Rezoning Transportation Analysis

Petition Number: 2020-157

General Location Identifier: Tax ID: 07106117

Date	Description
11-30-20	First Review (EL)

JOB NO.: 2020-105
DRAWN BY : MDN
DATE : 9.21.20
SCALE: 1"=20'
TECHNICAL DATA SHEET & EXISTING CONDITIONS
RZ.1

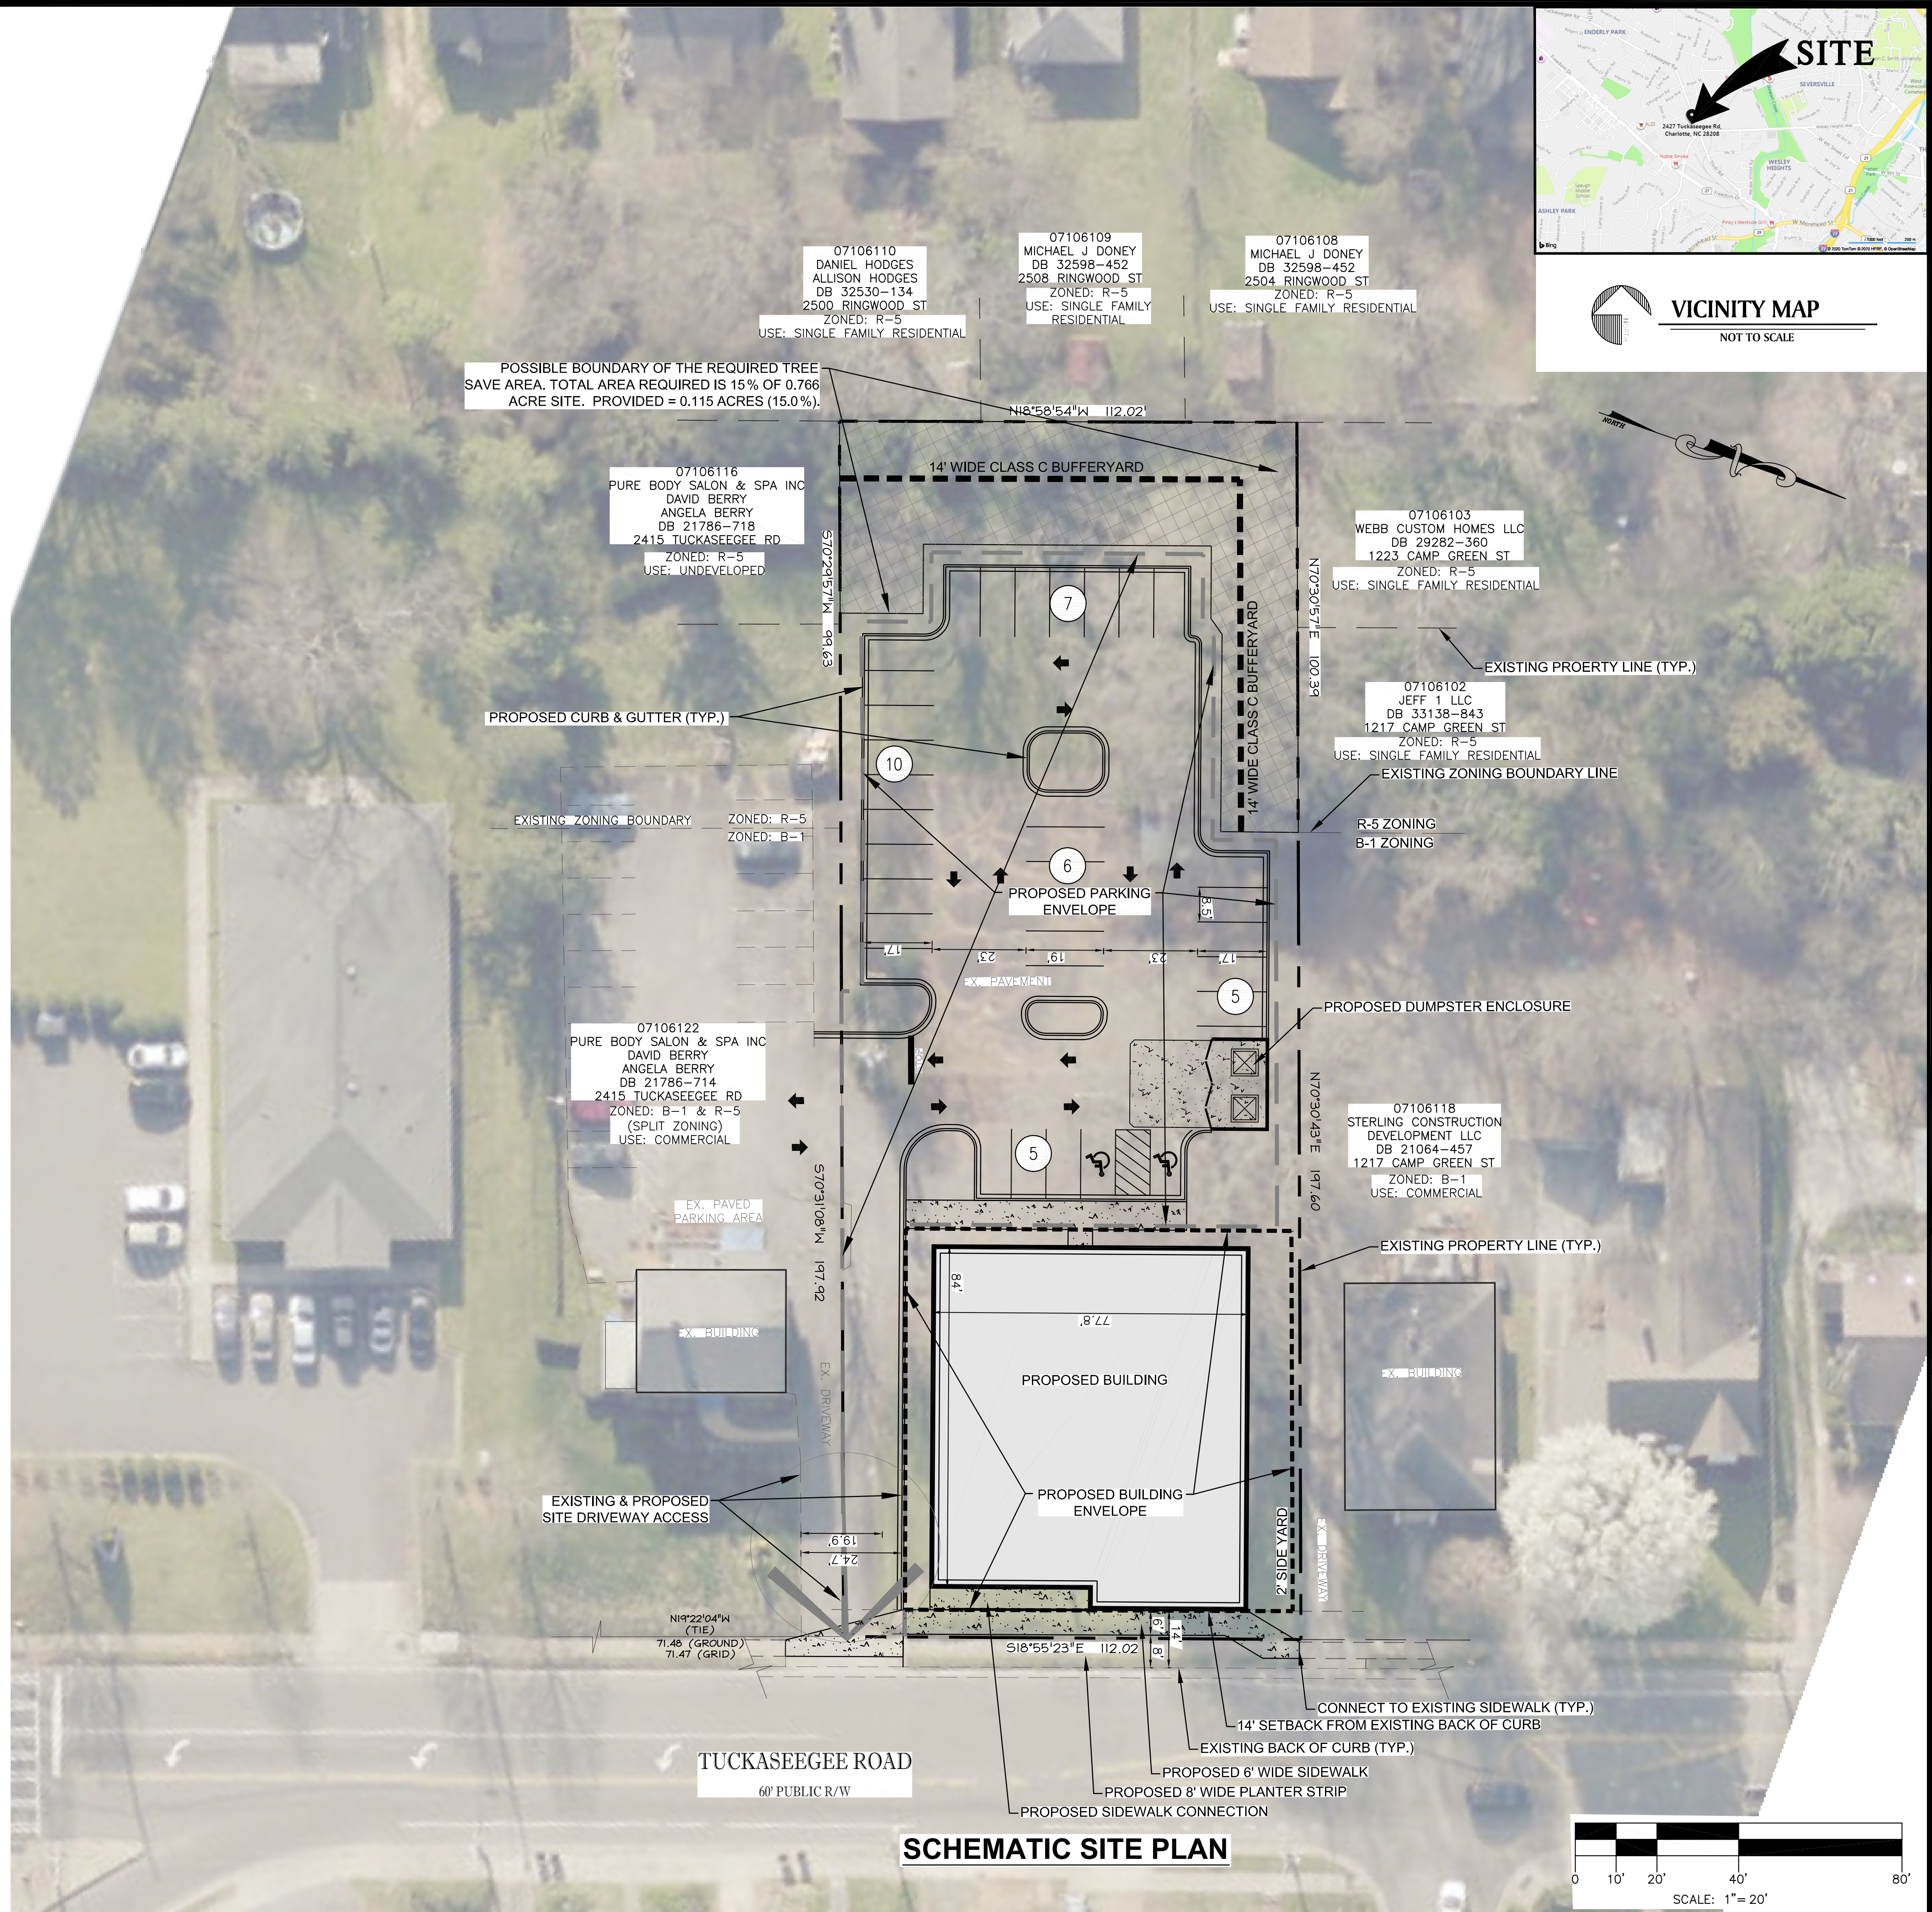
1. **Curbline:** The proposed zoning district has a setback measured from back of the existing or proposed future curbline.
 - a. **Tuckaseegee Road:** Location of curb and gutter and proposed streetscape improvements need to be coordinated with CDOT's Project Manager, Alfred Oyoyo, for the active Tuckaseegee/Berryhill/Thrift Roundabout CIP project. The CIP project's proposed improvements along this property's frontage are shown below. Contact CDOT to schedule a design coordination meeting to align the CIP project's improvements with this rezoning petition's proposed improvements.

Label and dimension the curb and gutter from the centerline for each road on the site plan.
